Application for Planning Permission for Works or Extension to a Dwelling

Development: Erection of single storey side and rear extension and installation of new 1 x front window following the demolition of existing single storey side and rear extension.
Location: 10 St Richards Road Westergate Aldingbourne PO20 3RD

I regret that I am unable to accept your documents as a valid application until the following item(s) have been received or resolved :-

BLOCK PLAN

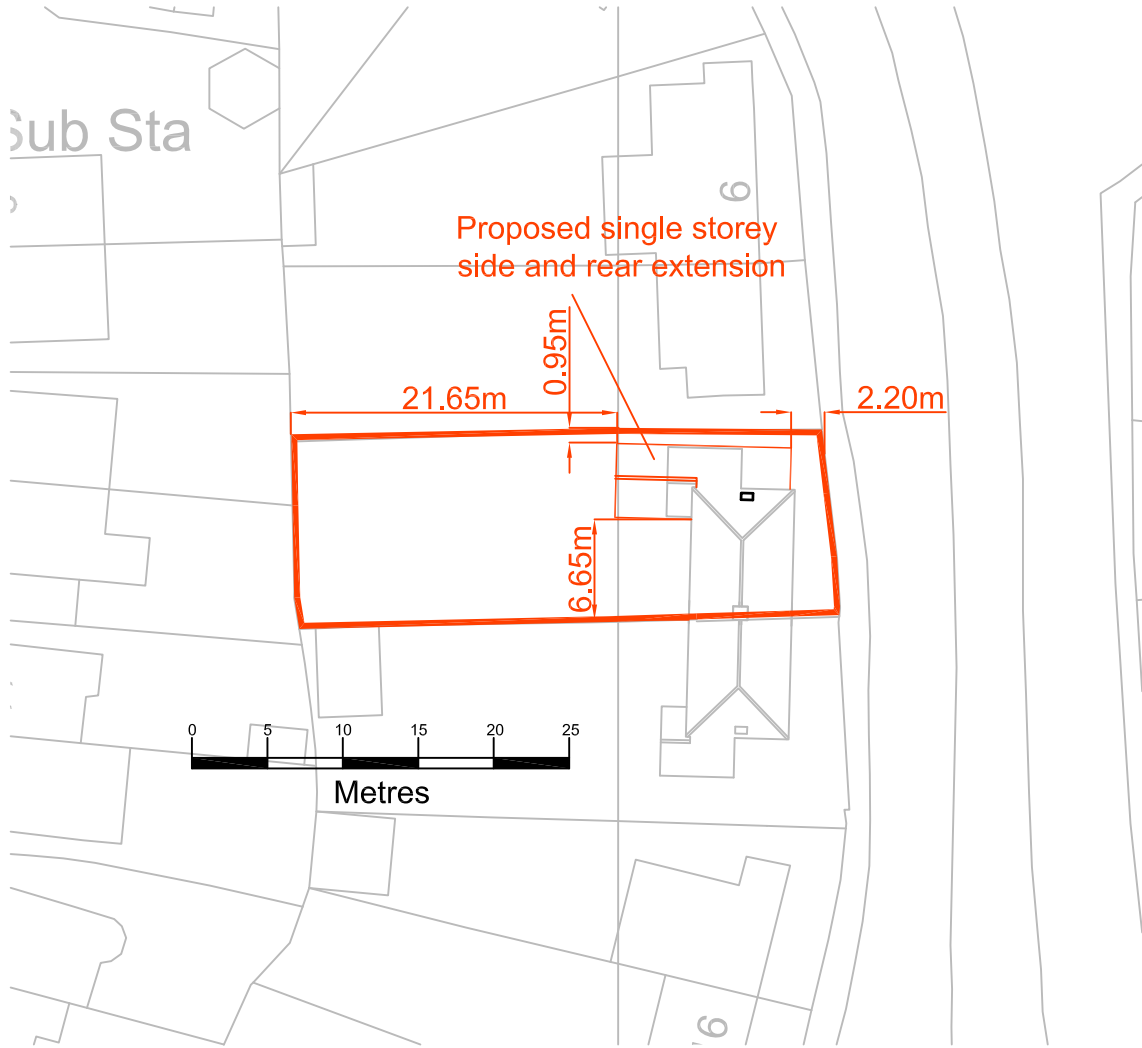
Block Plan

You are required to have dimensions from the proposed extension(s) to all site boundaries. Please amend
